Our Ref: TR020005/ PD-025

**Application by Gatwick Airport Limited for an Order Granting Development Consent
for the Gatwick Airport Northern Runway Project**

Request for further information and written comments

DRAWING TITLE
Proposed Car Parks

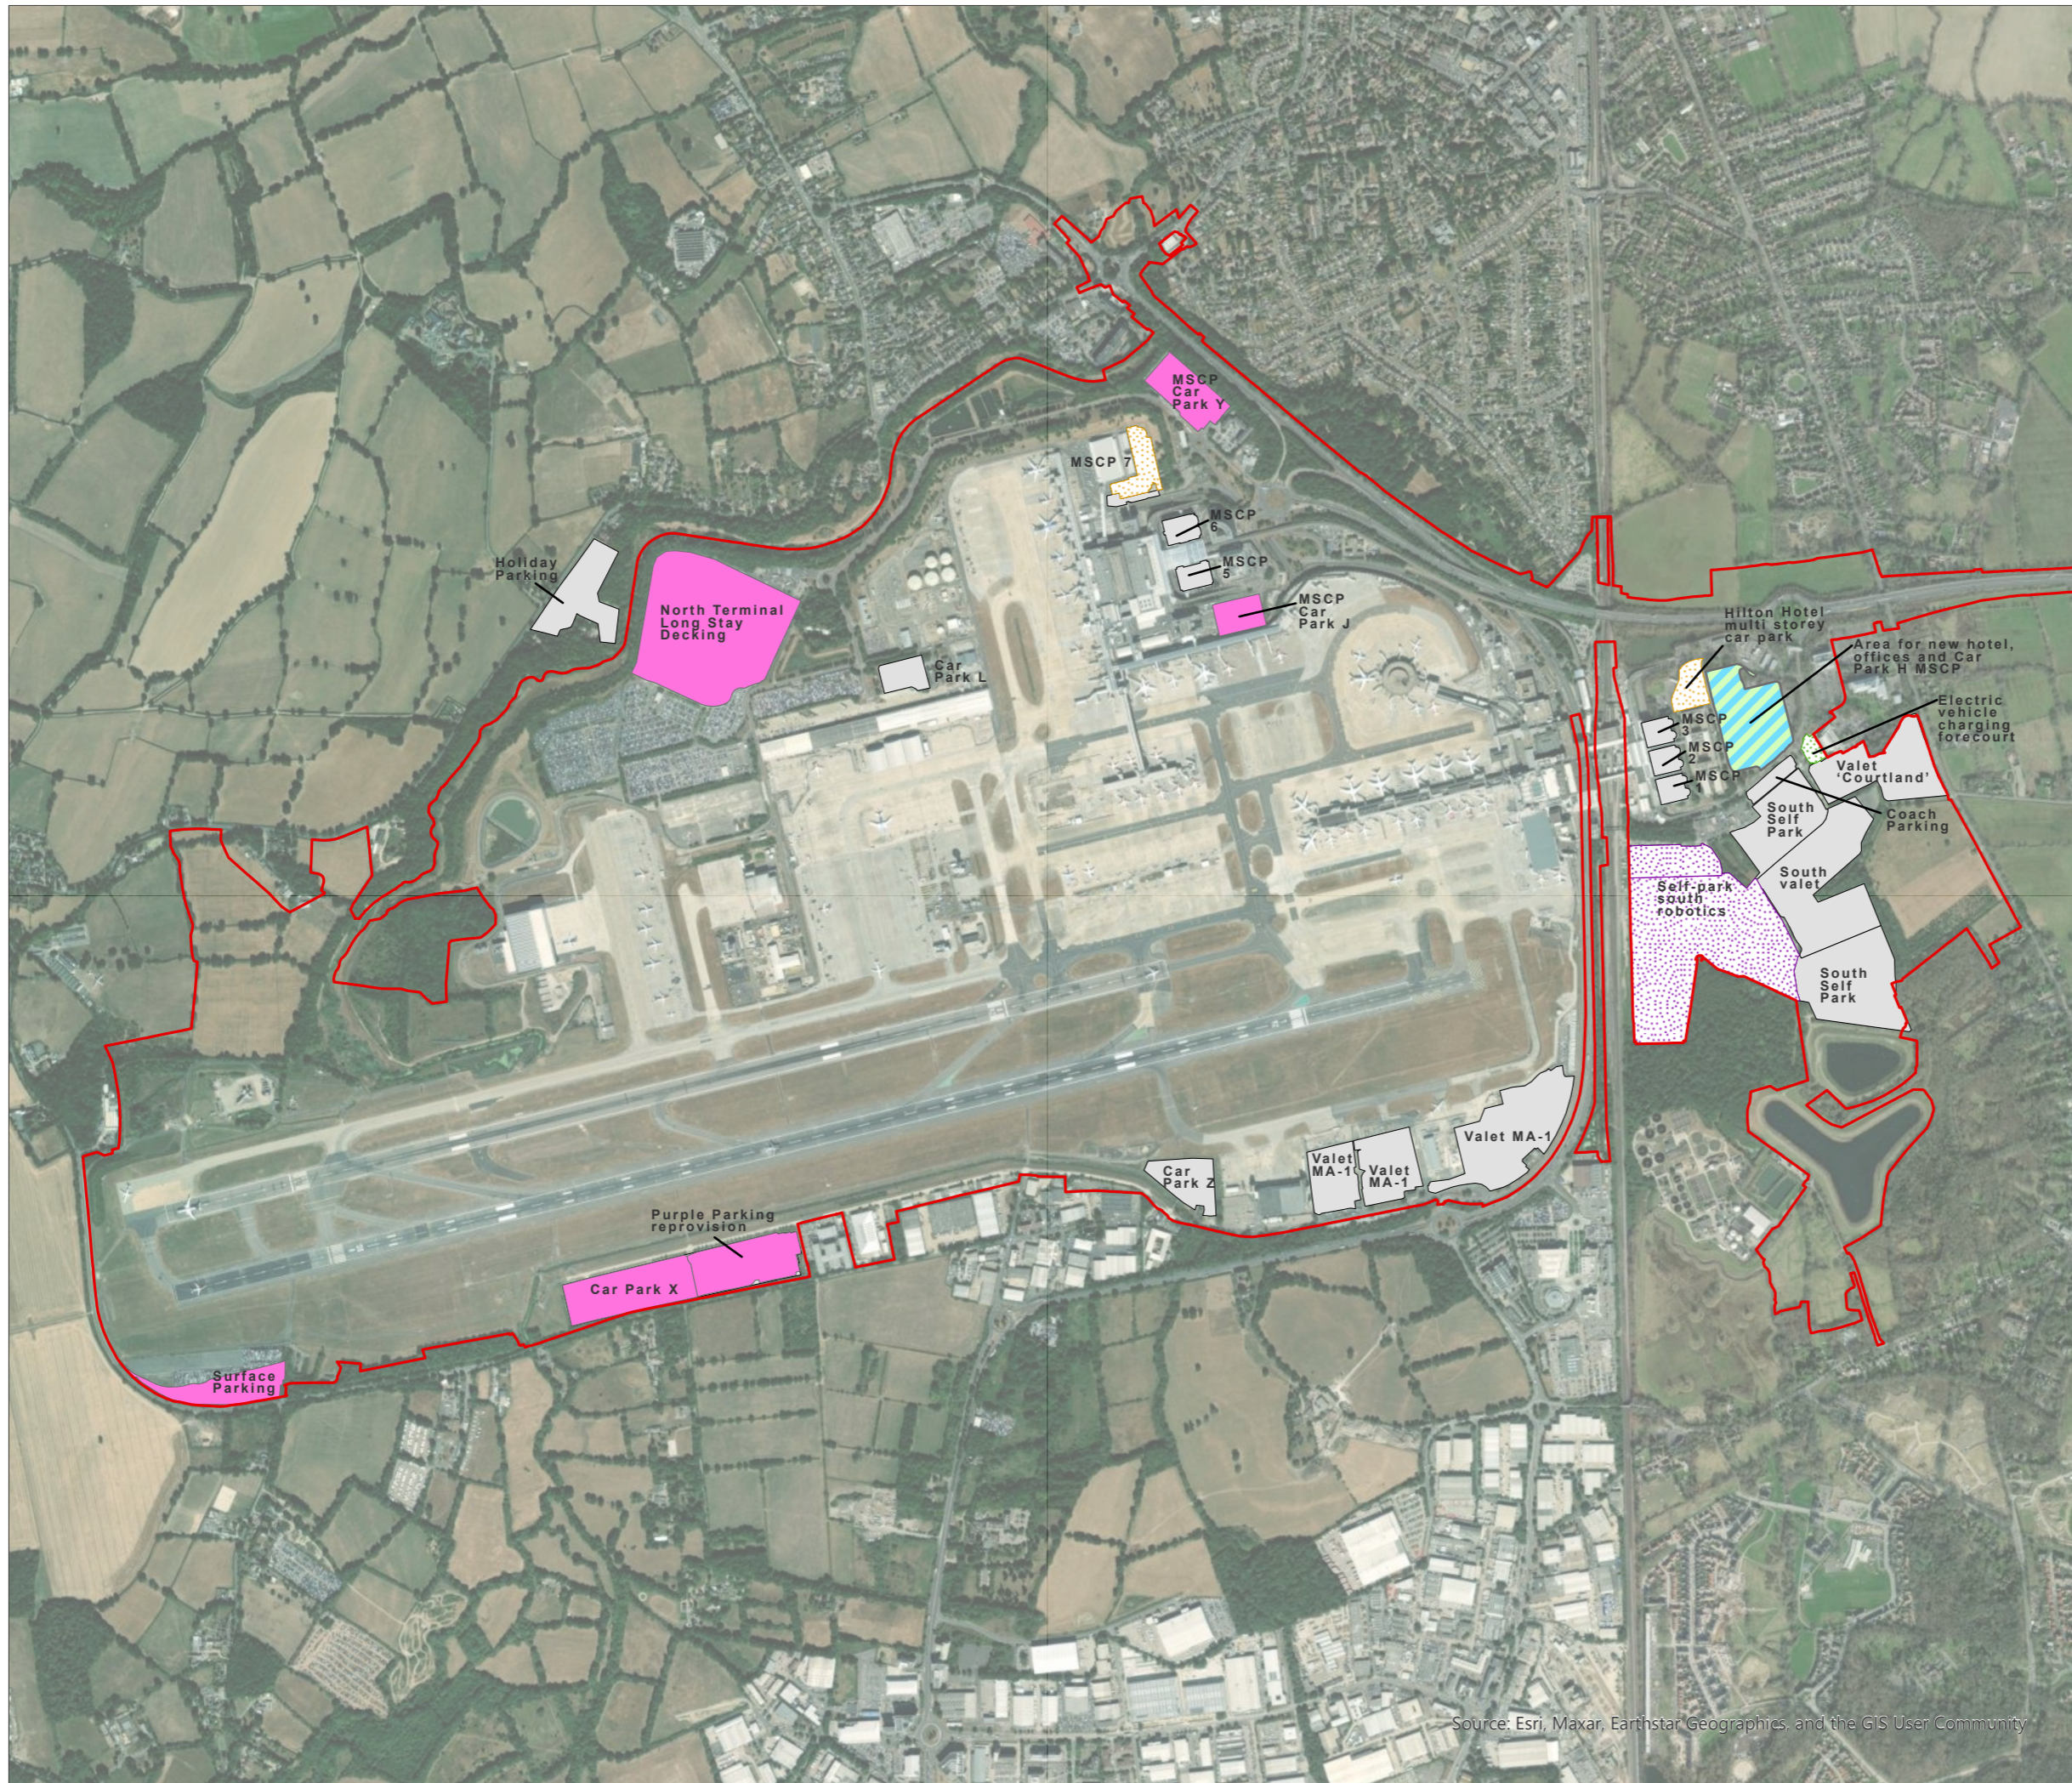
R17c	Question to:	Question:
R17c.1	The Applicant	<p>North Terminal Decked Long Stay Parking.</p> <p>As part of Project Change No. 4 for the proposed onsite Wastewater Treatment Works (WTW) it is proposed to replace the resulting lost surface car parking by increasing the size of the proposed decked car park on part of the North Terminal long stay surface car park. This revised decked car park would not increase in height but would increase in surface area. This enlargement of the area of this proposed decked car park would not require any alteration to the draft DCO [REP6-005]. The only control specified in the draft DCO is the 11.0m height shown on the Parameter Plans [REP6-011] and in Schedule 13 of the draft DCO.</p> <p>ES Chapter 5 Project Description [REP6-013] has been updated to allow for the replacement of surface parking lost by increasing the size of this decked car park. In paragraph 5.2.116 and Table 5.2.2 the level of replacement parking has been increased. The draft DCO would allow for this increased number of decked car park spaces to be constructed and used even if the onsite WTW is not constructed and the existing surface car parking had not been lost. In this scenario there would be an additional 1162 spaces constructed, which have not been accounted for in any of the submitted assessments. How would this scenario be controlled by the draft DCO?</p>

R17c.2	The Applicant	<p>Draft DCO [REP6-013] – Control Over Parking.</p> <p>The parking scenario set out in the above question raises the possibility that parking numbers on site could be increased without further consent. Estimate:</p> <ol style="list-style-type: none"> <li data-bbox="629 1091 1935 1203">i. The theoretical maximum increase of onsite parking numbers that could be achieved by increasing the plan areas of all proposed decked or multi storey car parking to utilise all practically available corresponding surface parking site areas; and <li data-bbox="629 1208 2031 1362">ii. The theoretical maximum increase of onsite parking numbers that could be achieved by utilising existing permitted development rights under The Town and Country Planning (General Permitted Development) (England) Order 2015, Schedule 2, Part 8 Class F. This number should be based on the completed layout of the Proposed Development.
